DEPARTMENT OF THE ARMY
WILMINGTON DISTRICT, CORPS OF ENGINEERS
69 DARLINGTON AVENUE
WILMINGTON, NORTH CAROLINA 28403-1343

Action ID. SAW-2009-00556
NC DOT TIP No.: I-5111/I-4739

Subject: MODIFICATION of 401 Water Quality Certification Pursuant to Section 401 of the Federal Clean Water Act and NEUSE BUFFER RULES, with ADDITIONAL CONDITIONS for Proposed widening of I-40 from I-440 to SR 1525 plus improvements to NC 42 and SR 1010 in Wake and Johnston Counties; Federal Aid Project No. IMNHF-040-4(139)301; State Project No. 42346.3.1; TIP Nos. I-5111 & I-4739. NCDWR Project No. 20190593 ver 7.

| INCOMPLETE PLANS<br>DO NOT USE FOR R/W ACQUISITION               |                        |

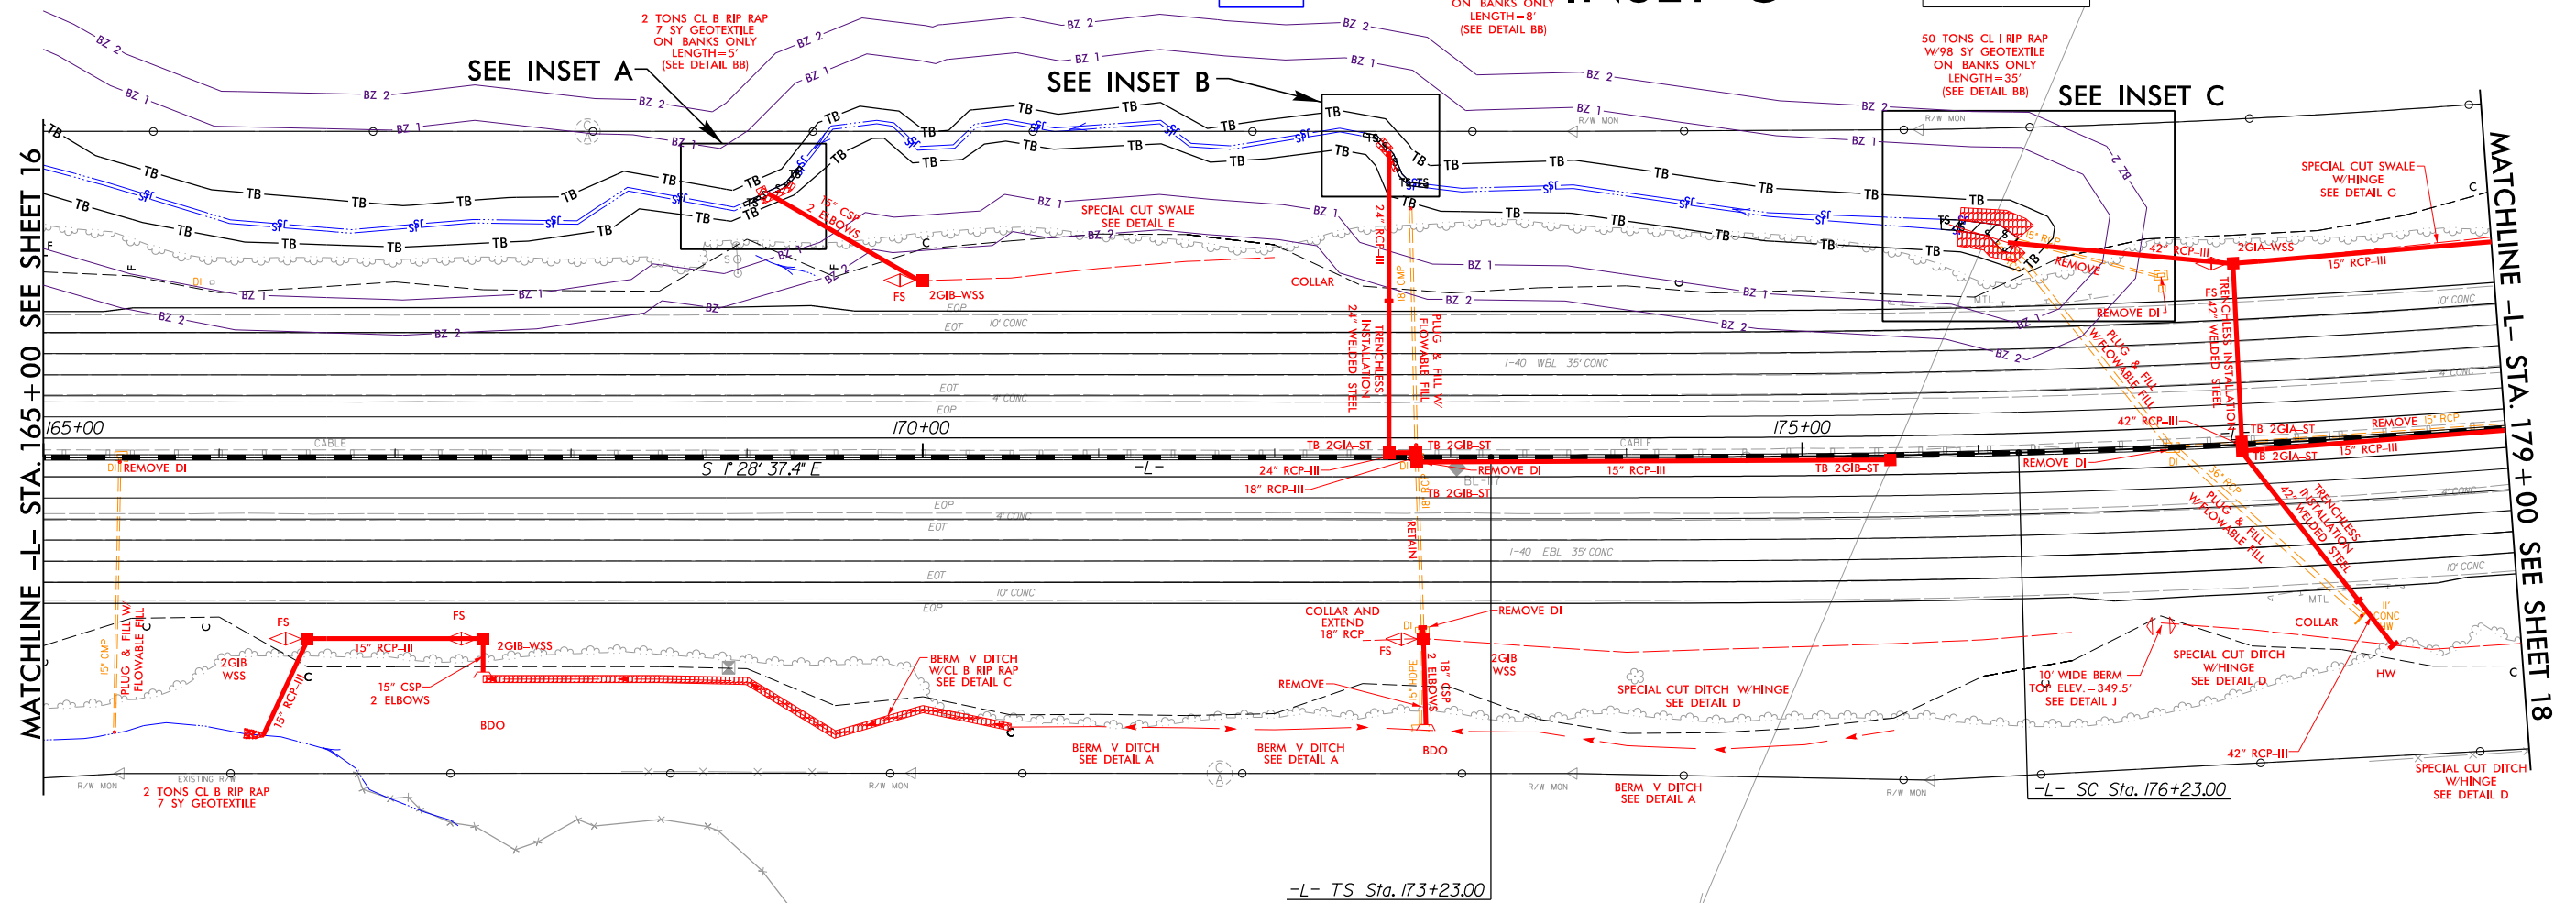
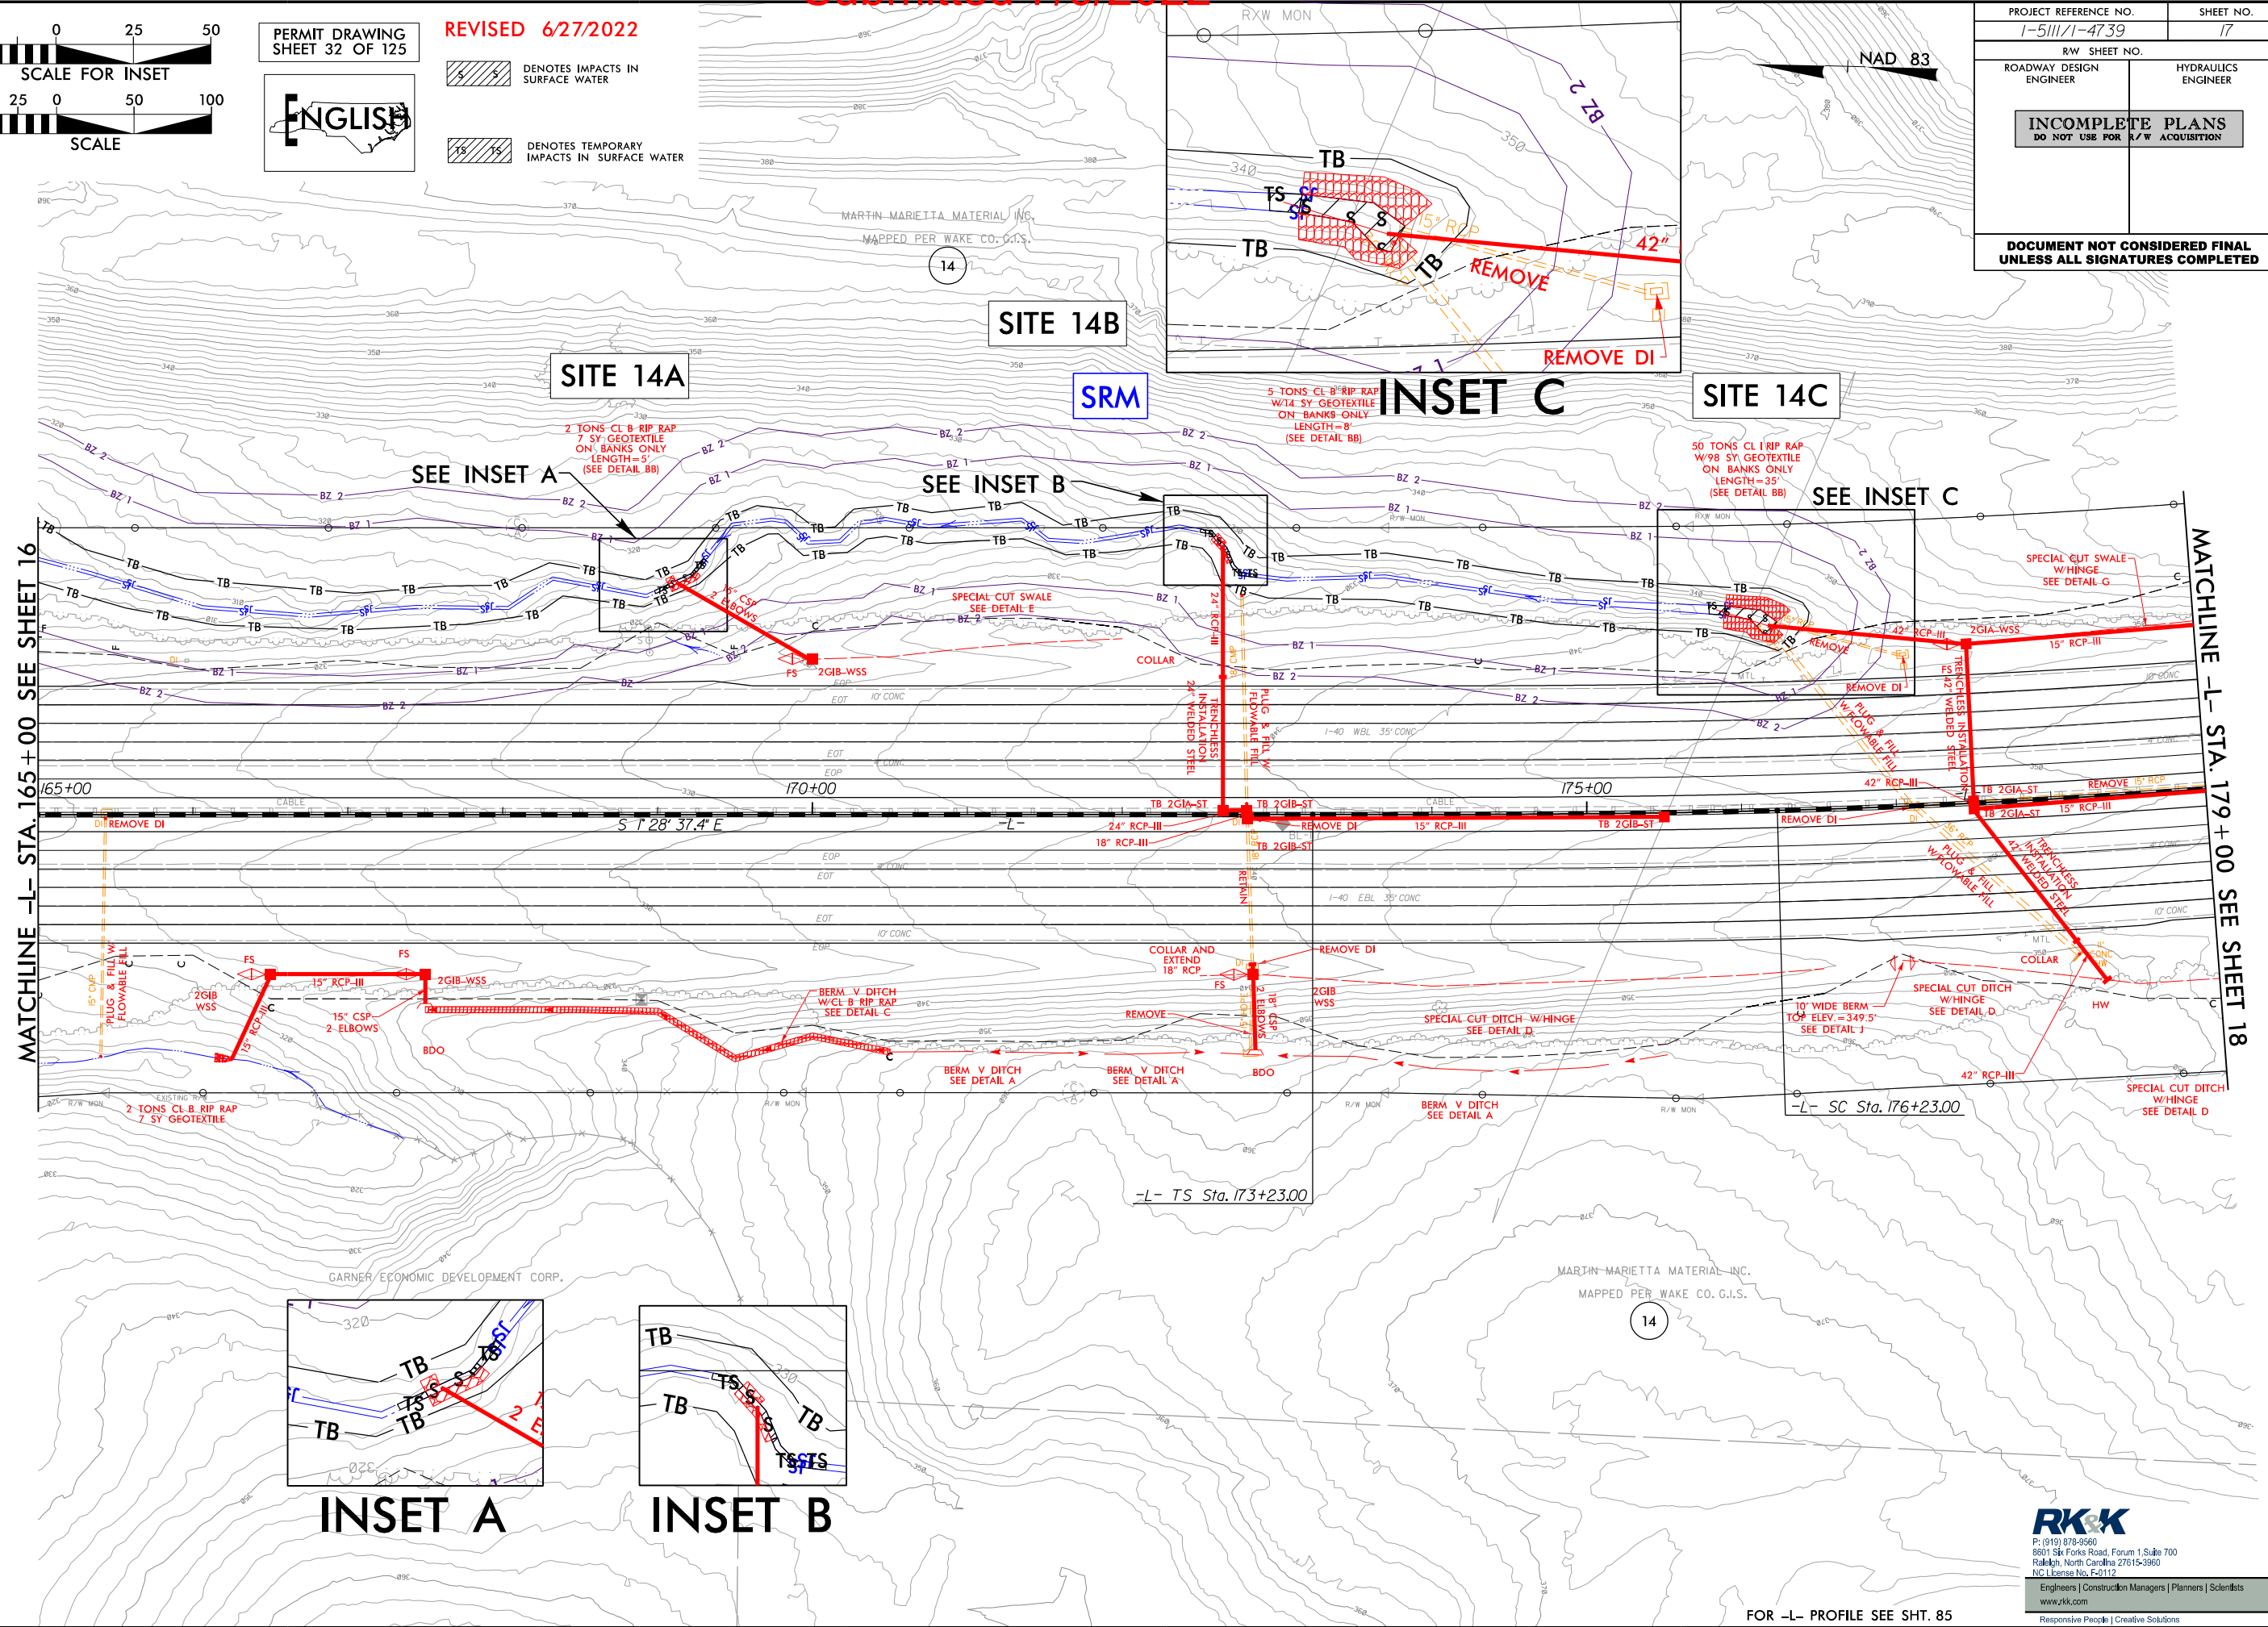
Site 14A: Additional bank stabilization is needed due to site conditions.

- 15 linear feet increase in permanent stream impacts (bank stabilization)

Site 14B: Additional bank stabilization is needed due to site conditions.

- 12 linear feet increase in permanent stream impacts (bank stabilization)
- 12 linear feet decrease in temporary stream impacts (bank stabilization)

- **+15 linear feet Stabilization permanent impact to Intermittent Stream**
 - **+400 square feet Zone 1 Buffer Mitigable Impact**
 - **+186 square feet Zone 2 Buffer Mitigable Impact**
- *Site 14A revised totals in application plan sheets July 6, 2022: 20 linear feet Permanent Stream Impact. 20 linear feet Temporary Stream Impact. 0 ac wetland impact. 2058 square feet Zone 1 Mitigable Buffer Impact. 1132 square feet Zone 2 Mitigable Buffer Impact.*

- **+12 linear feet Stabilization permanent impact to Intermittent Stream**
 - **-12 linear feet (decrease) Temporary intermittent stream impact**
- *Site 14B revised totals in application plan sheets July 6, 2022: 20 linear feet Permanent Stream Impact. 31 linear feet Temporary Stream Impact. 0 ac wetland impact. 1824 square feet Zone 1 Mitigable Buffer Impact. 1680 square feet Zone 2 Mitigable Buffer Impact.*

The authorized work shall be completed in accordance with the attached revised permit drawings sheets 17 and 49 of 125 submitted on July 6, 2022, and the Wetland and Surface Water Impact Summary Sheets 122 and 125 of 125 submitted on July 6, 2022. As there are an additional 40 linear feet of permanent stream impacts, compensatory mitigation is required at a 2:1 ratio for the permanent stream impacts associated with this modification. As proposed in the modification request, compensatory mitigation must be completed by debiting an additional 80 linear feet of compensatory stream mitigation credits from the official ledger for NCDOT's Marks Creek Mitigation Site in Wake County.

REVISED 6/1/2022

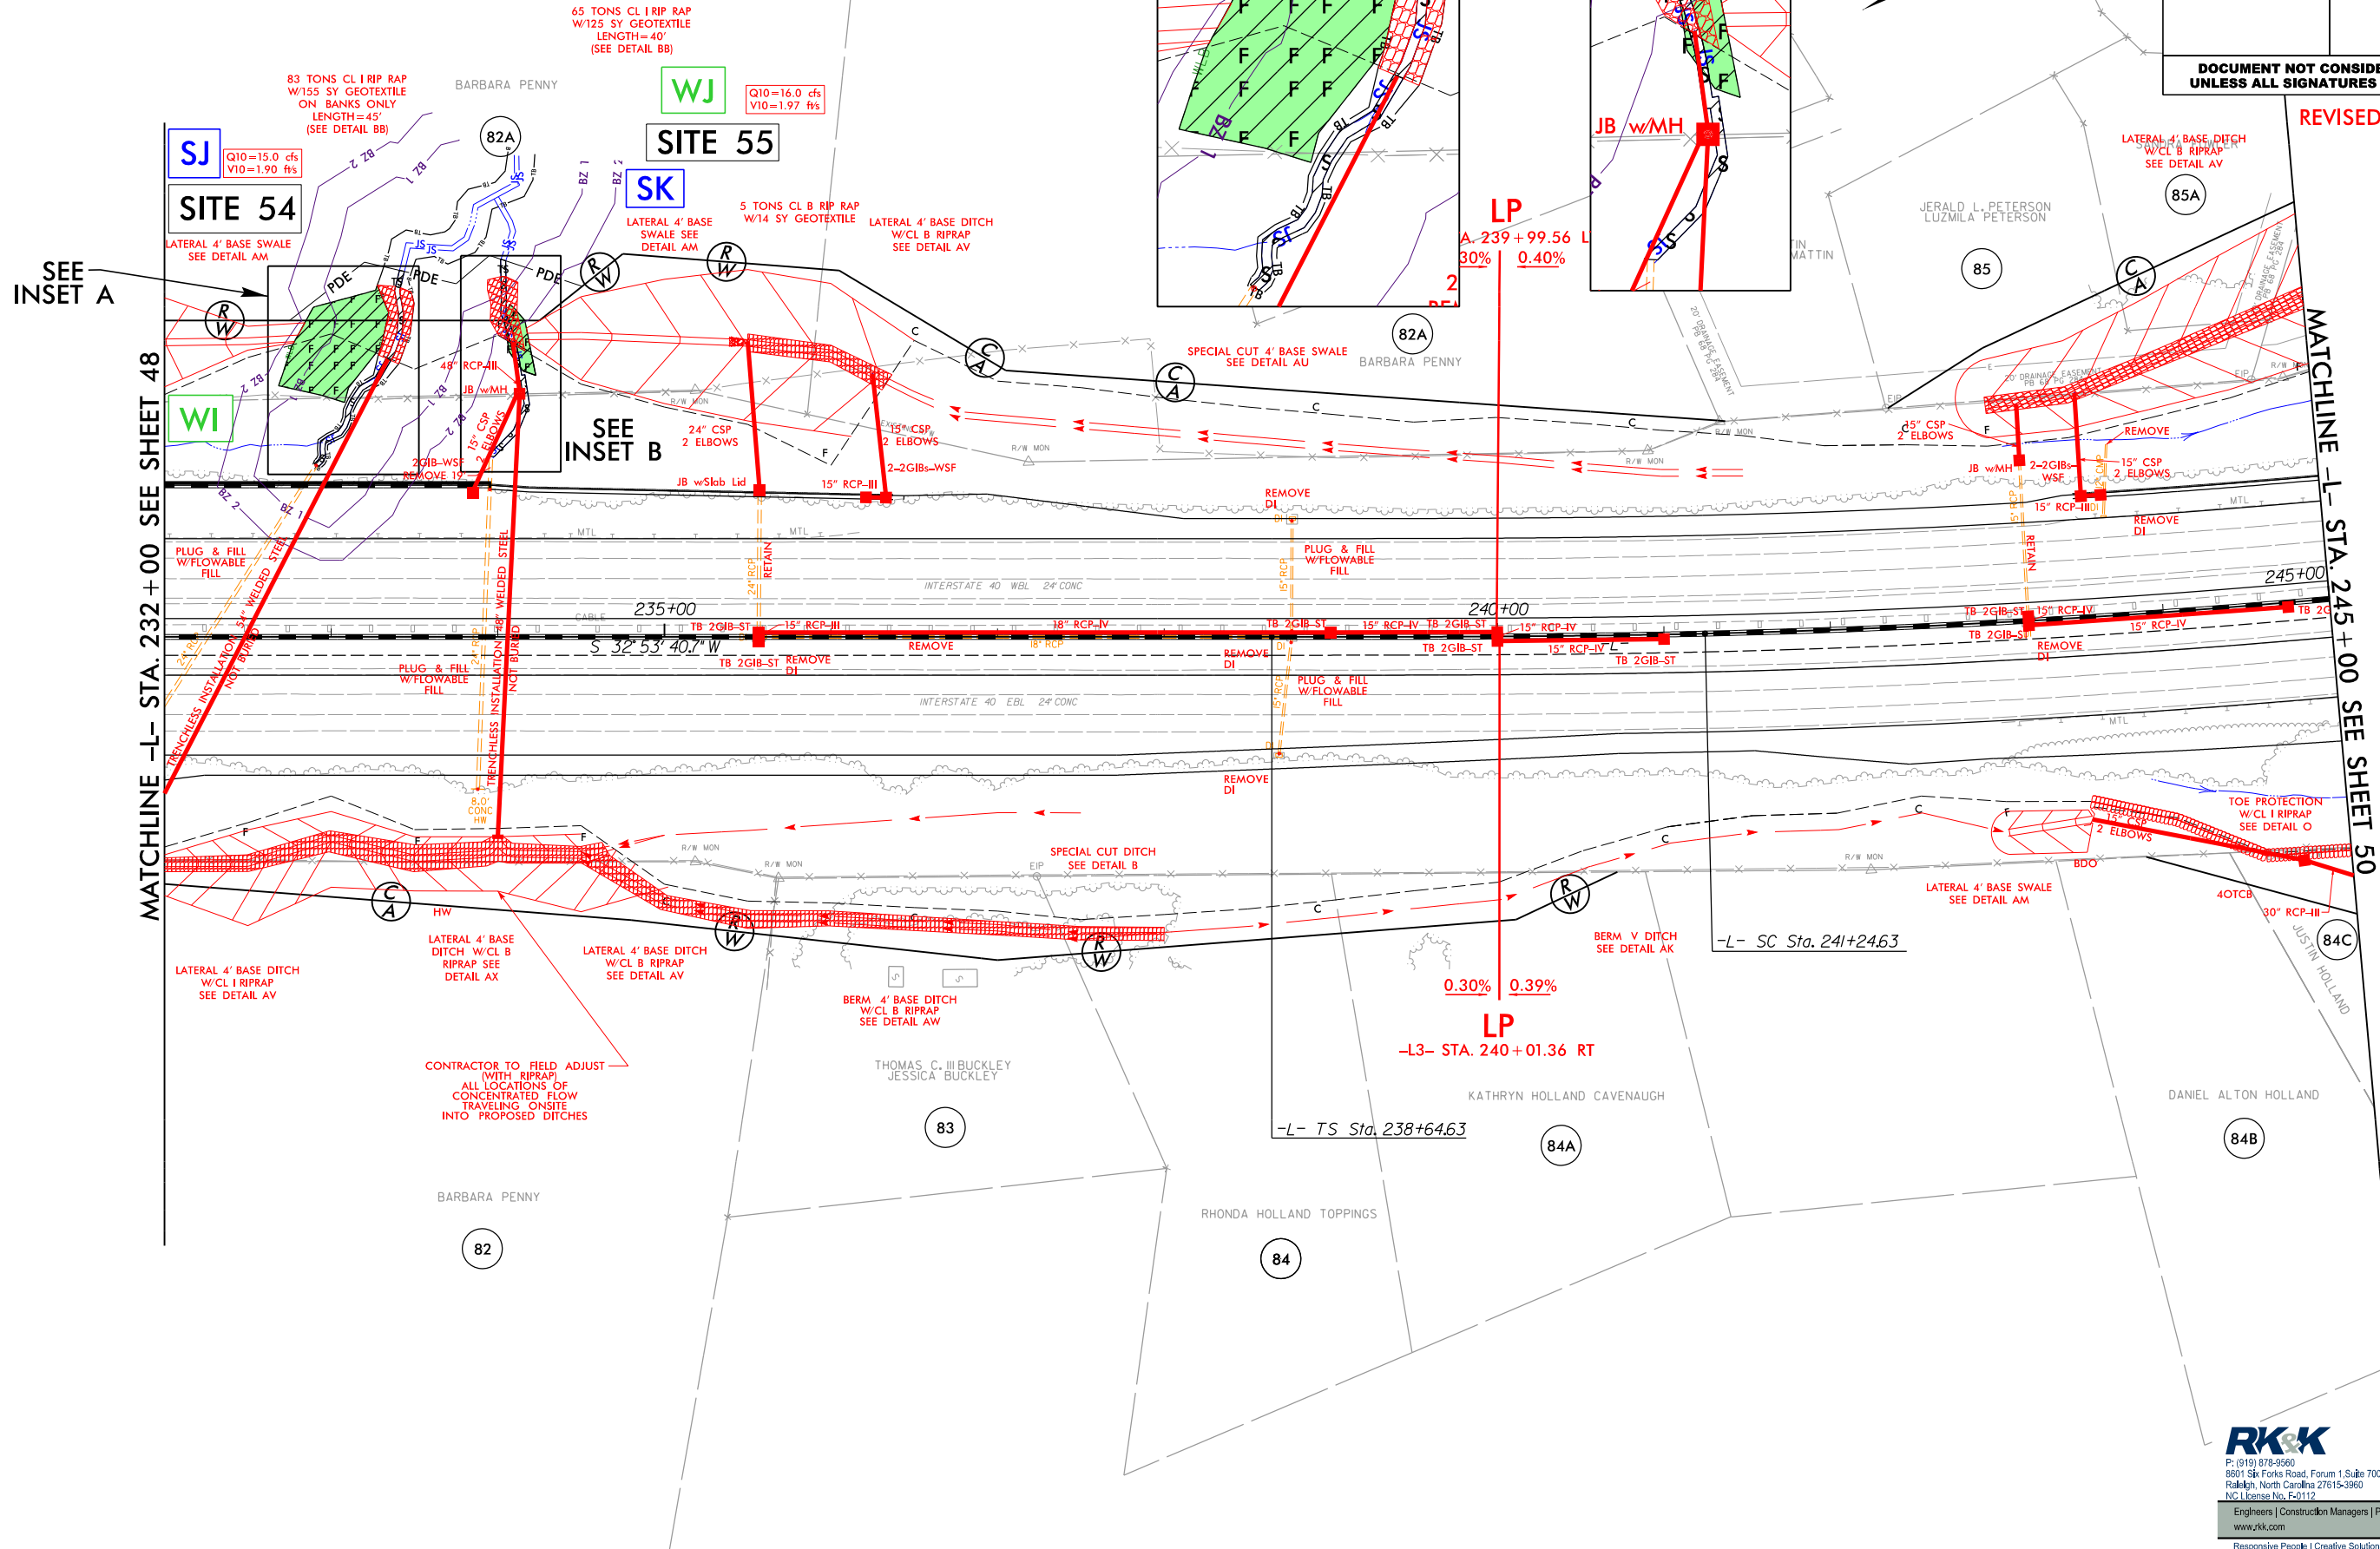
Site 55: Due to repeating erosion events and the general instability of the channel below the outlet, rip rap would be added to the flow line to match the length of the previously permitted bank stabilization.

- 40 linear feet decrease in bank stabilization impacts
- 40 linear feet increase in permanent stream impacts

- **+40 linear feet Stabilization permanent impact to Perennial Stream**
 - **-40 linear feet (decrease) Temporary Perennial Stream impact**
- *Site 55 revised totals in application plan sheets July 6, 2022: 118 linear feet Permanent Stream Impact. 10 linear feet Temporary impact. 0.01 ac wetland impact. No buffer impact.*
